**Byers Gill Solar
EN010139**

8.16 Comments on Deadline 3 Submissions

Deadline 4 – October 2024

Drawing Title
**Panel Area A
Vehicle Access - Aycliffe Lane/
Brafferton Lane/ The Green
Sheet 1 of 9**

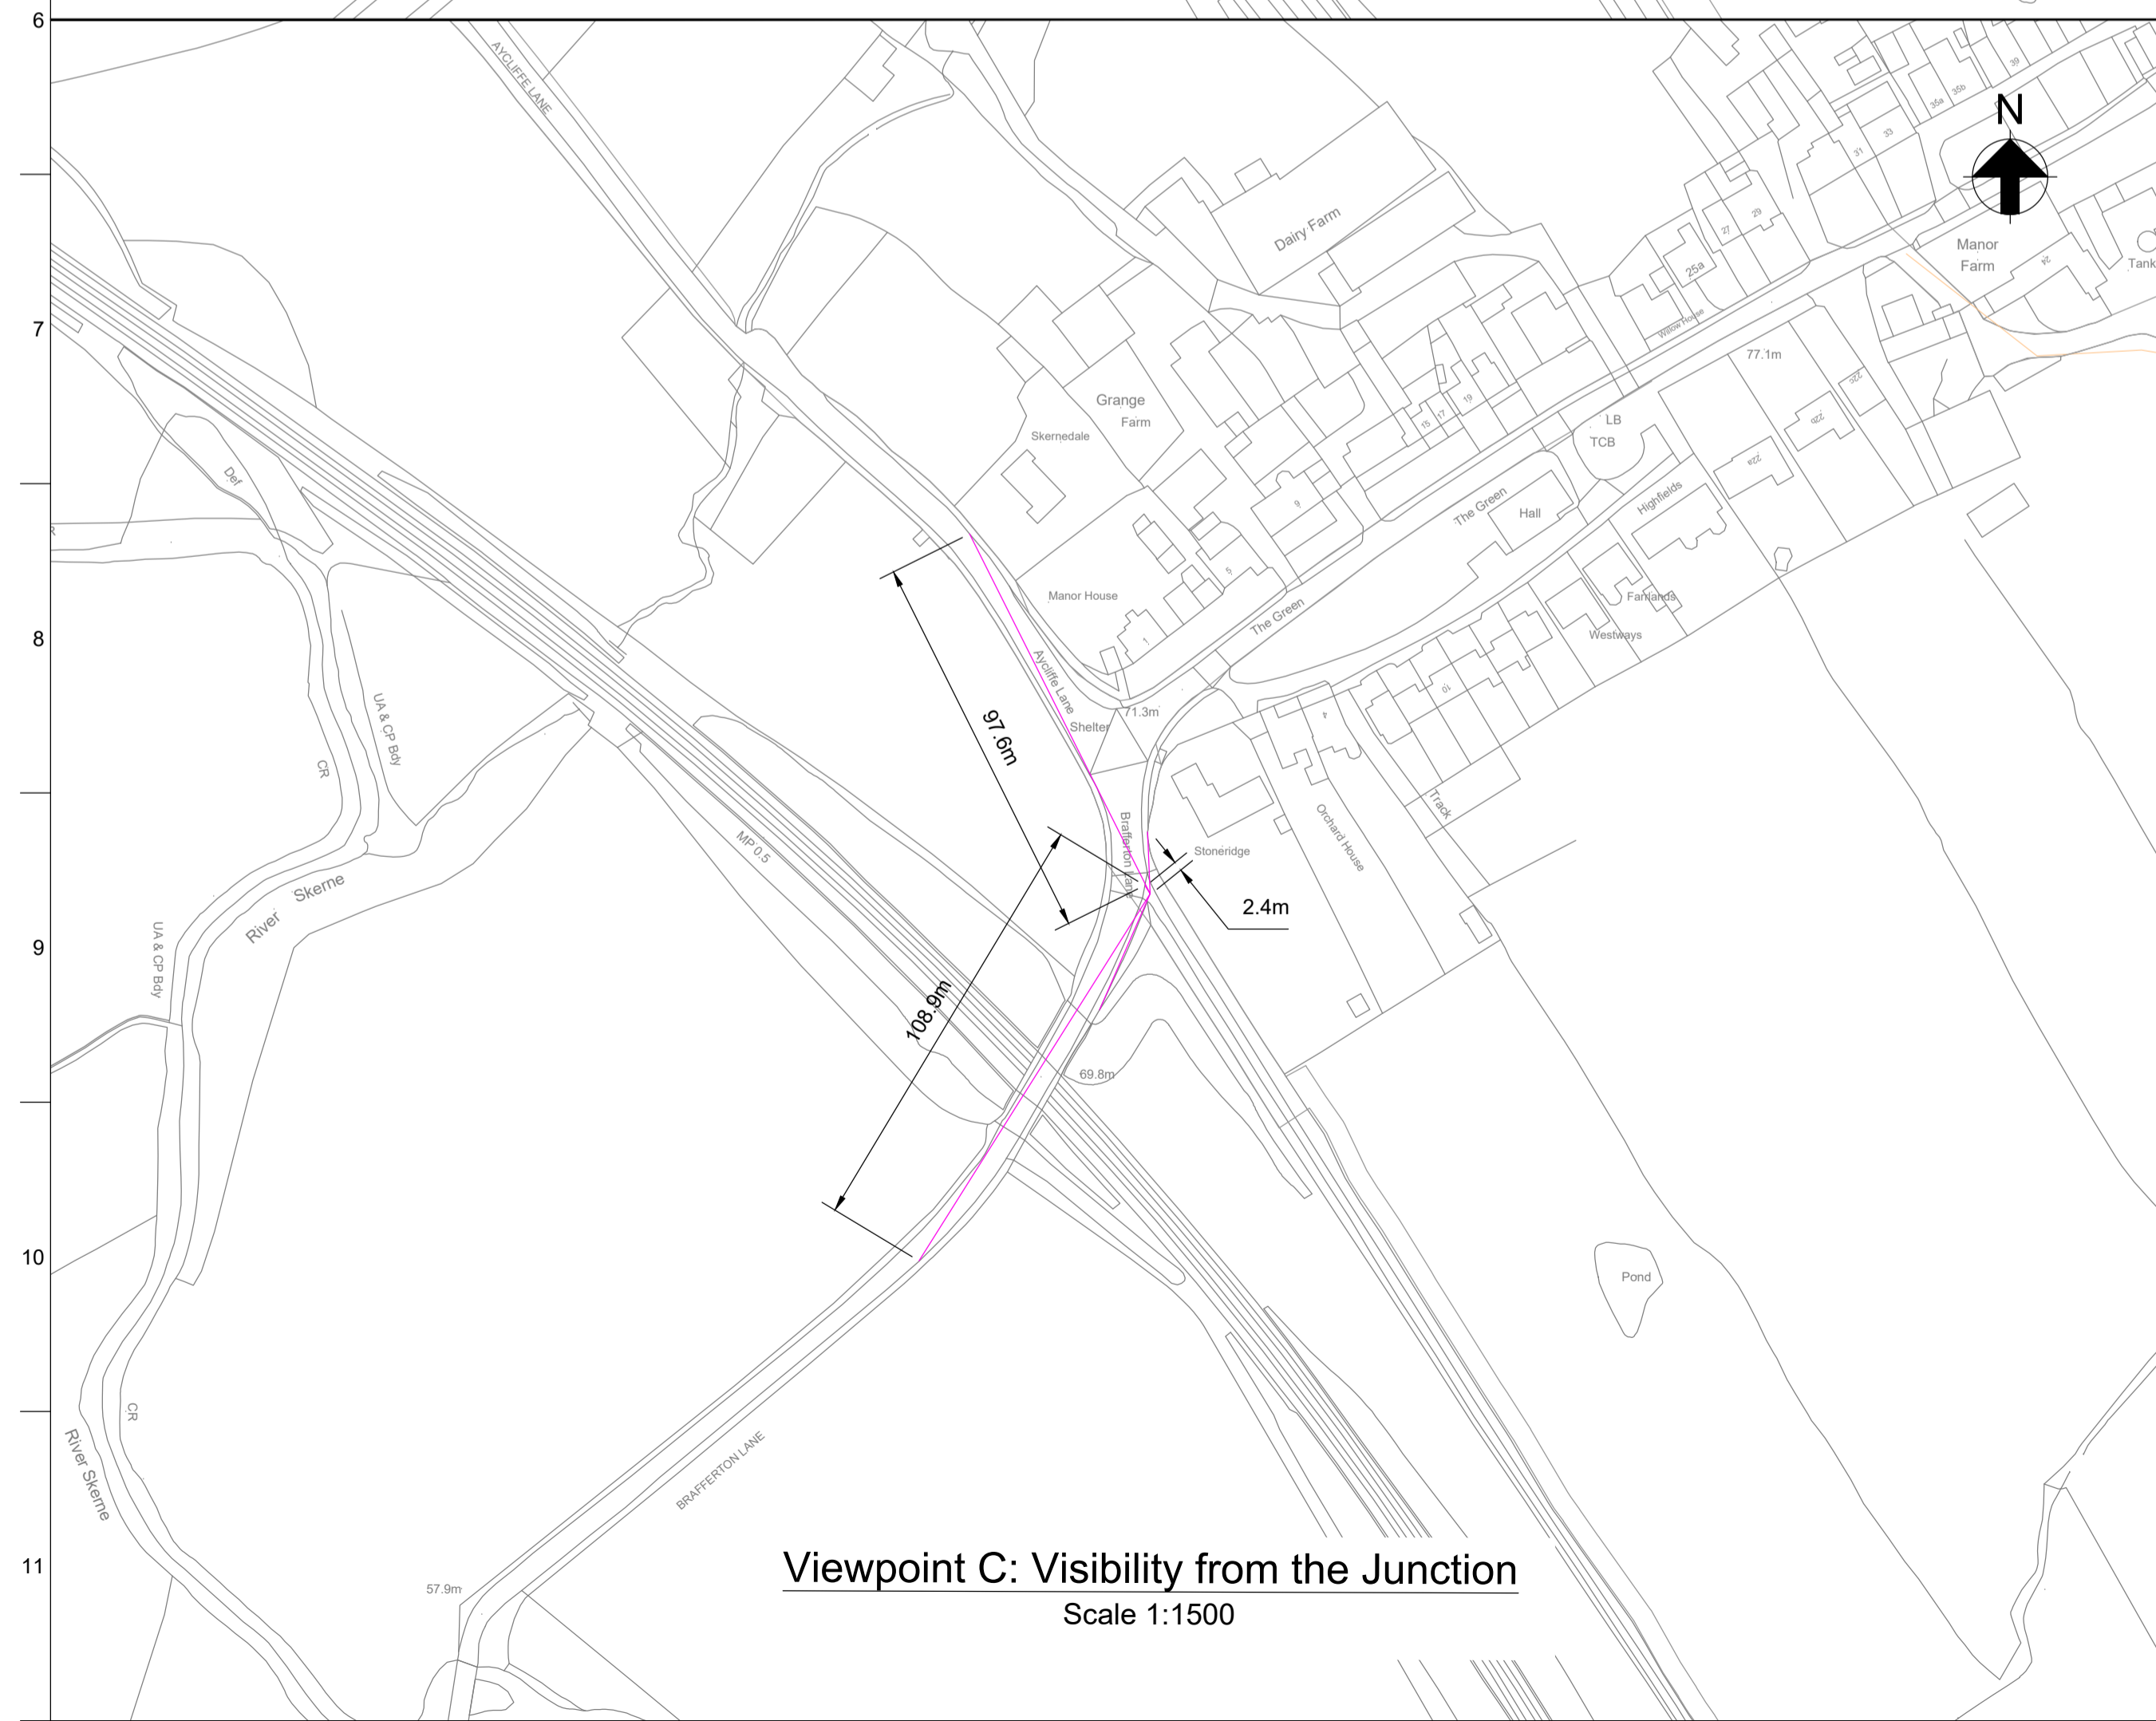
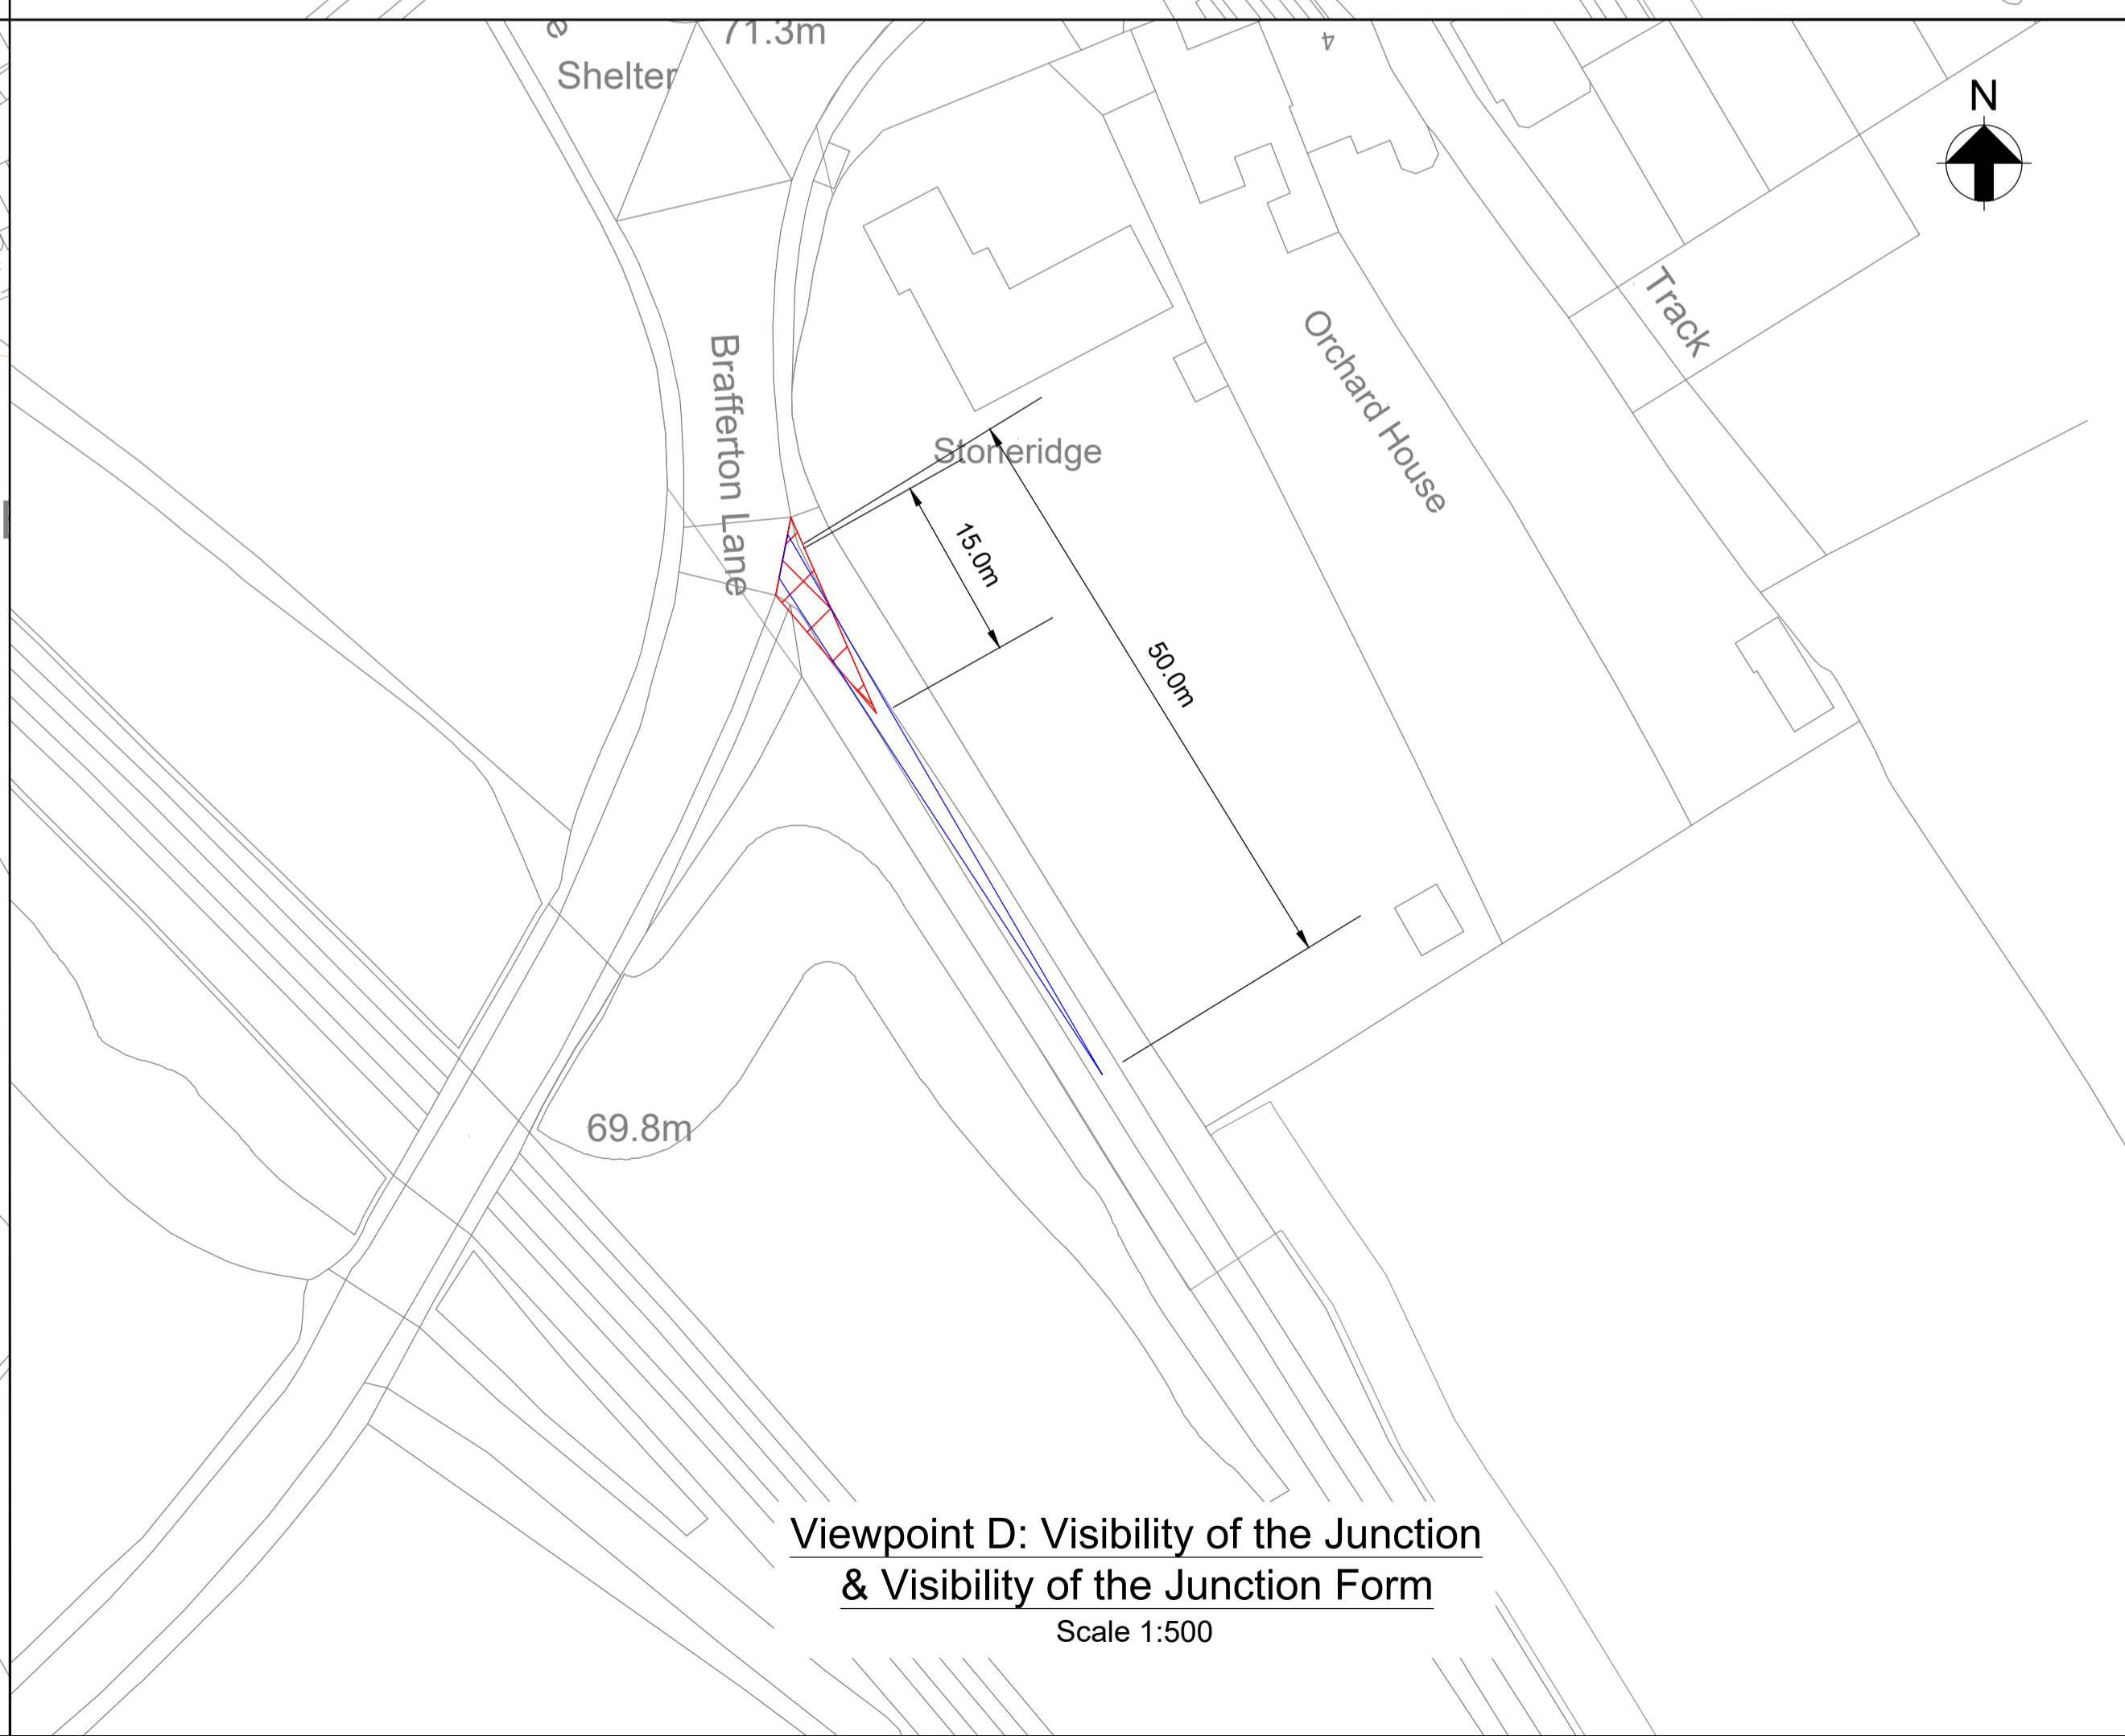
REP3-016	Bishopton Villages Action Group (BVAG)	In relation to ExQ1 TT.1.23, BVAG raise concern regarding proposed site accesses, particularly to Panel Area A.	The Applicant notes BVAG's concerns regarding the access to Panel Area A, referencing BVAG's Landscape & Visual Review [REP2-044]. Comments have been provided regarding this in the submitted document Comments on Written Representations REP2-042 (Bishopton Villages Action Group) and REP2-044 (Landscape & Visual Review) [REP3-005]. The Applicant considers the accesses to be sufficient, with detailed design to be developed post-consent. However, as discussed at the Issue Specific Hearing 2 on 15 October 2024, the Applicant and Darlington Borough Council Highways Department have been in recent discussion on the accesses, including sharing of visibility splays. An update on these discussions is expected by Deadline 5.
